Our Case Number: ACP-324447-26

Re: Proposed Upgrades to the Mortarstown Wastewater Treatment Plant and Kilkenny Road Pumping Station
Carlow, County Carlow

SID Online Observation

The Glen Resident Association

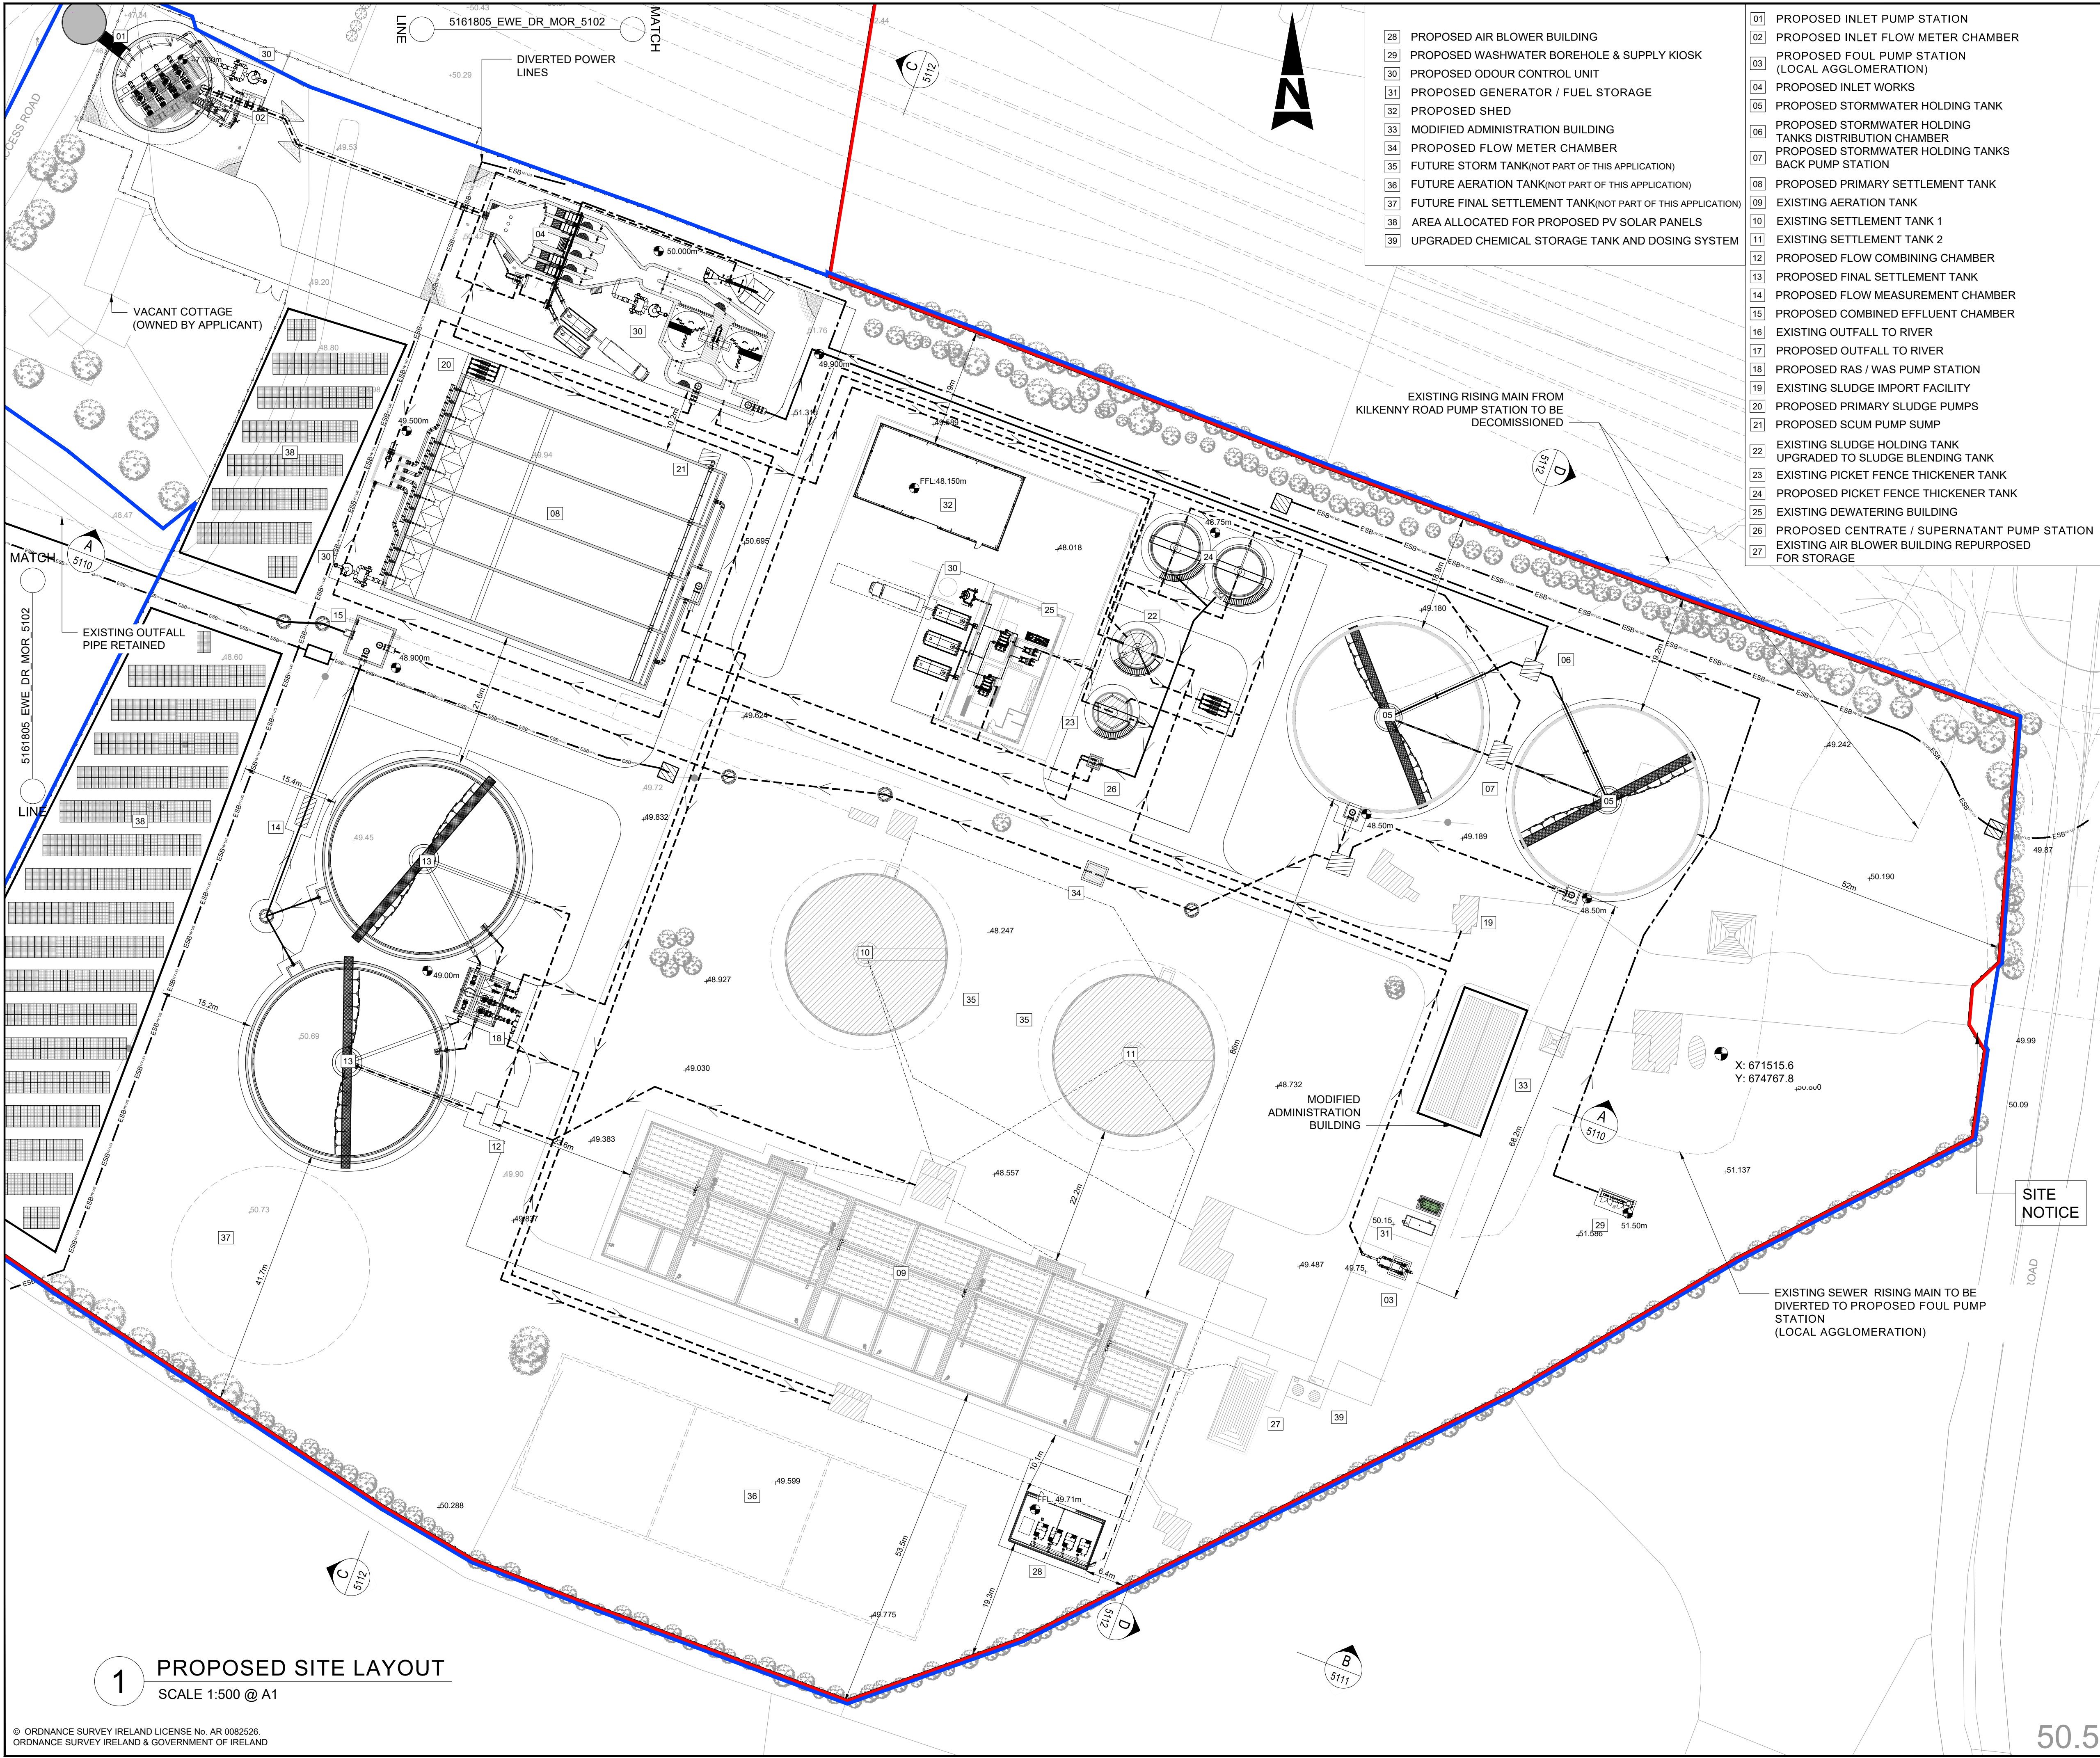
We have issue with the development's location on the site plan, especially the sludge handling area

The existing sludge processing area is too close to the northeast fence; this is an issue as wind travels in this direction, and the Glen residential estate area is approximately 60 meters from this fence downwind.

The sludge/sewage part of the plant is too close to the northeast boundary and does not allow proper dispersion of odours created as such does not allow proper dispersion of the odour from this area, because of proximity to The Glen estate

It is also noted that the north fence line is adjacent to the new Carlow relief road proposal, therefore exposing the public walking, driving and cycling only a couple of meters along this fence line and exposed to unacceptable odours, this has not been addressed in this application as far as we can determine.
